RE: CPD Project #1808-026-SUB1 – Responses & Revisions

This letter is in regards to corrections and revisions for the project at 6600 82<sup>nd</sup> Ave SE, 98040. Please review this document with the re-submitted (SUB2) plan set.

A3.1

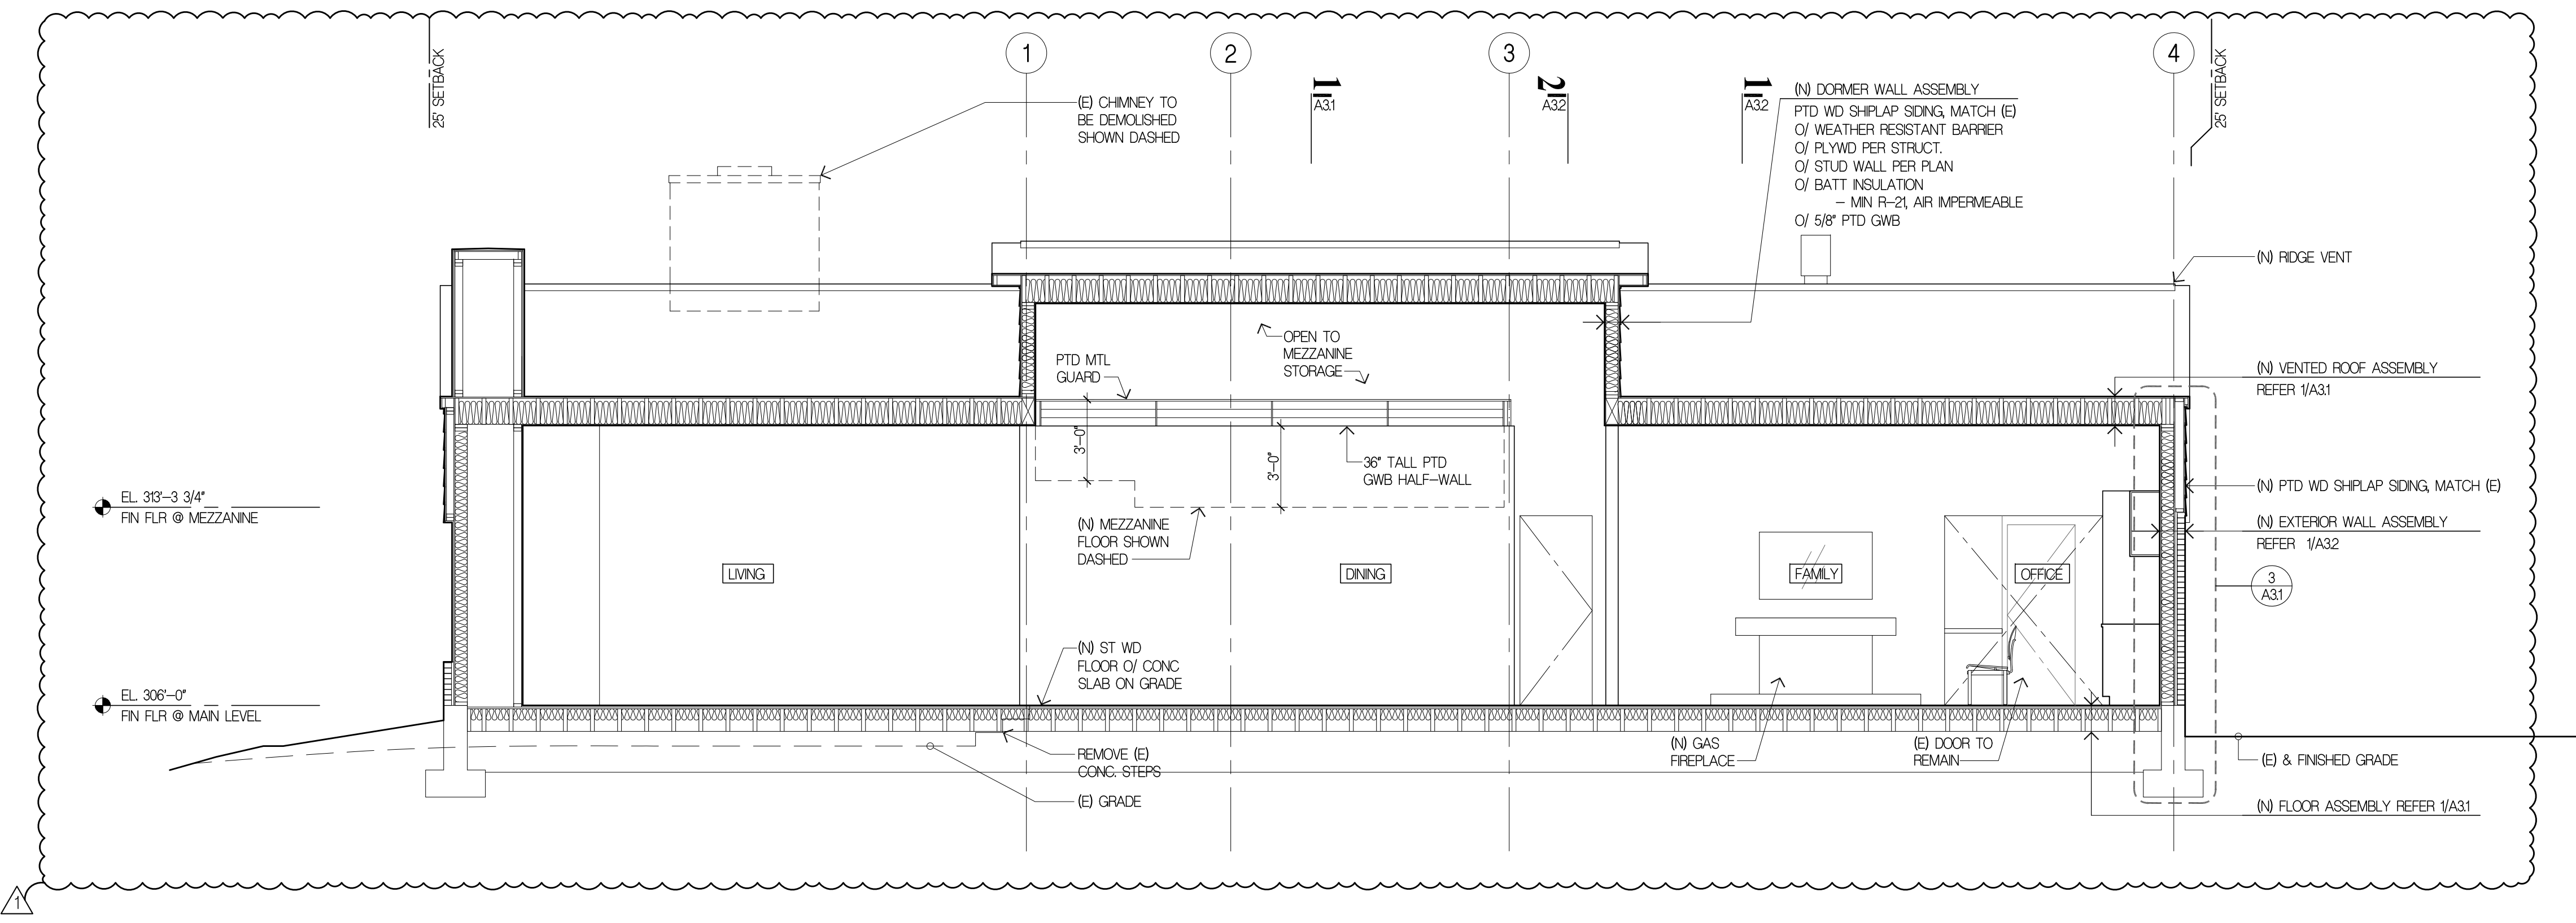
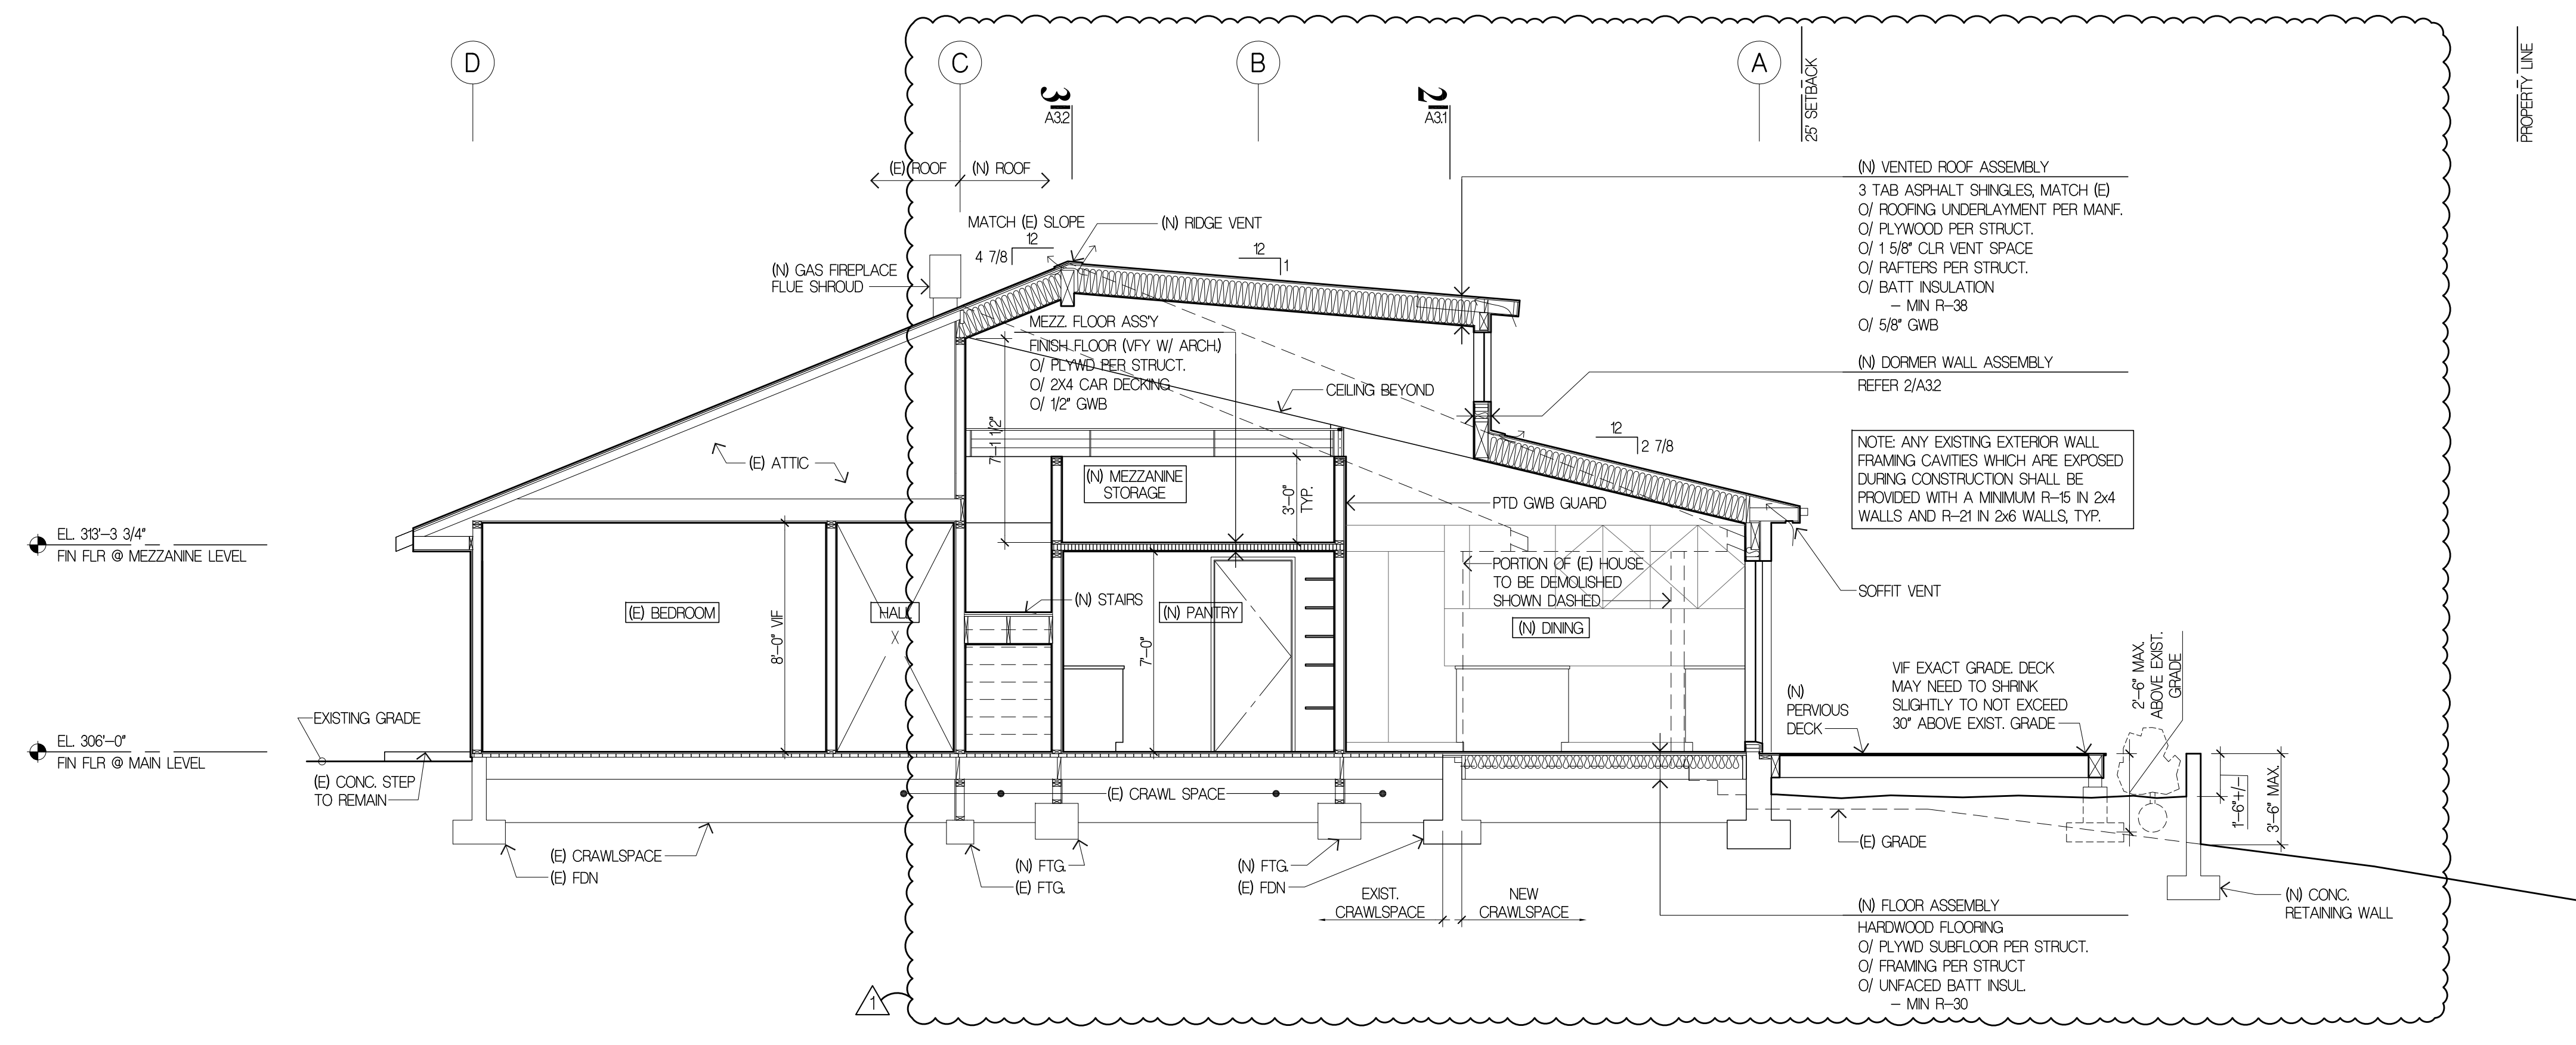
- Sections updated to reflect revised design
- Enlarged wall section added

2 SECTION LOOKING NORTH
 1/4"=1'-0"
 A-B&dwg

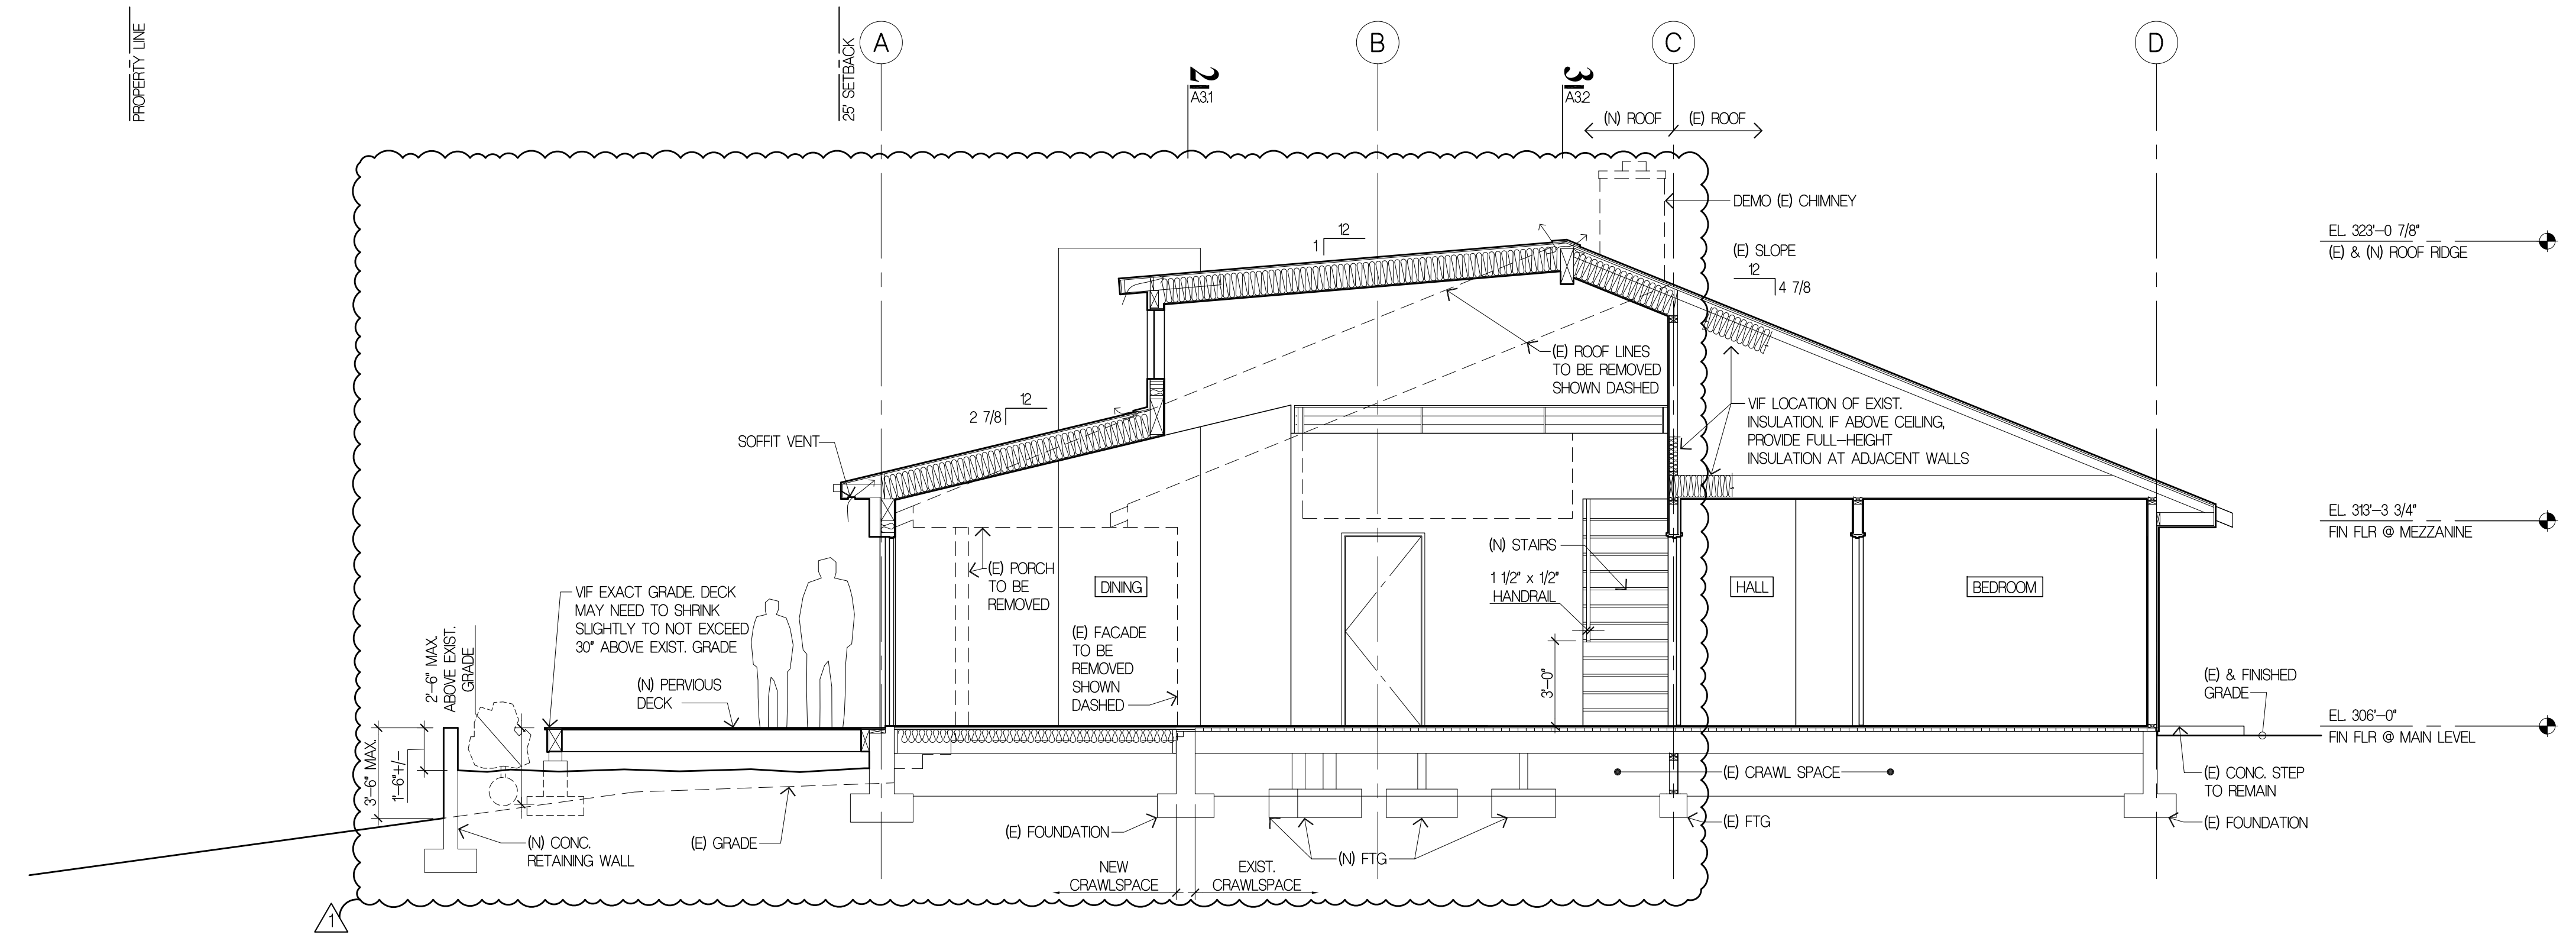
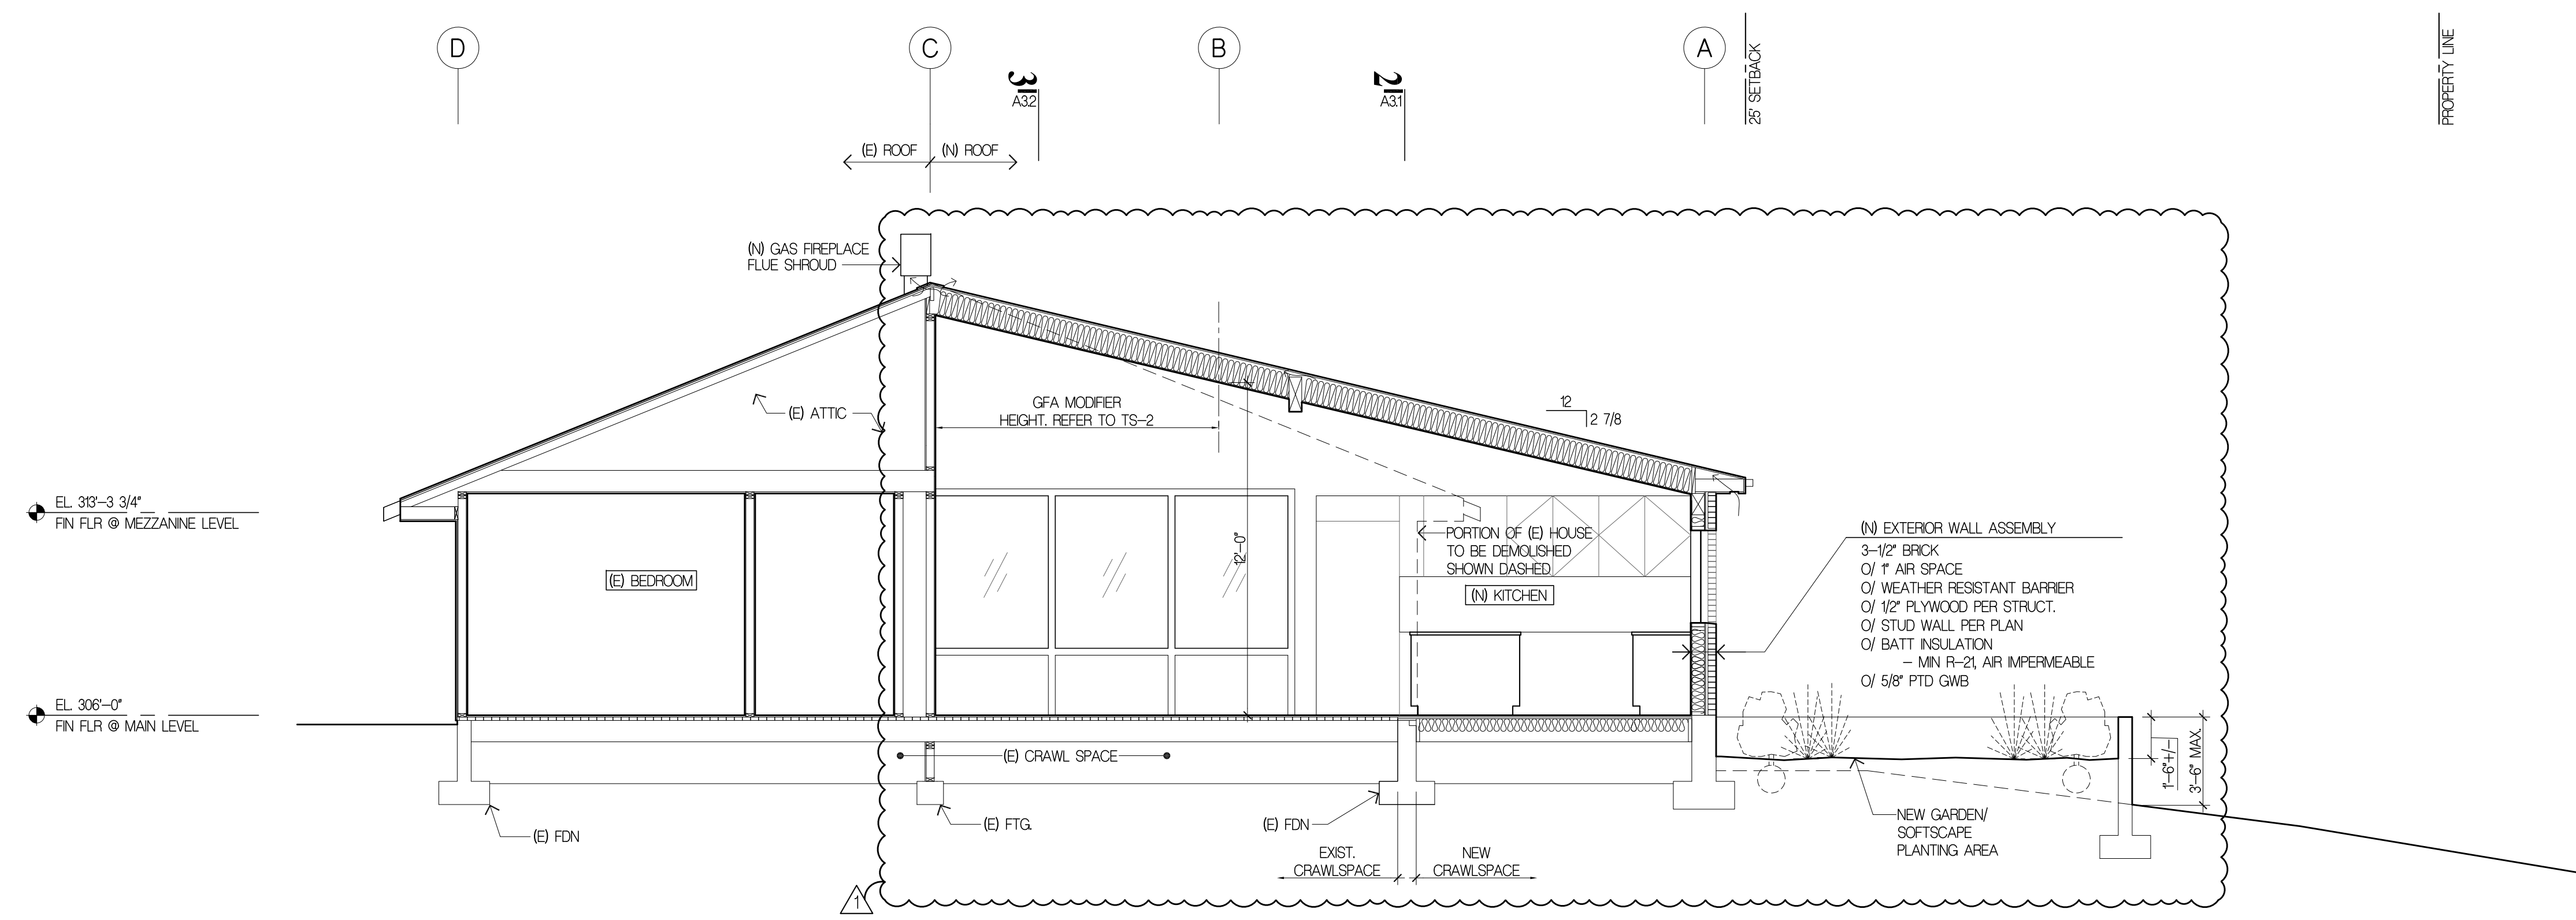
- Sections updated to reflect revised design
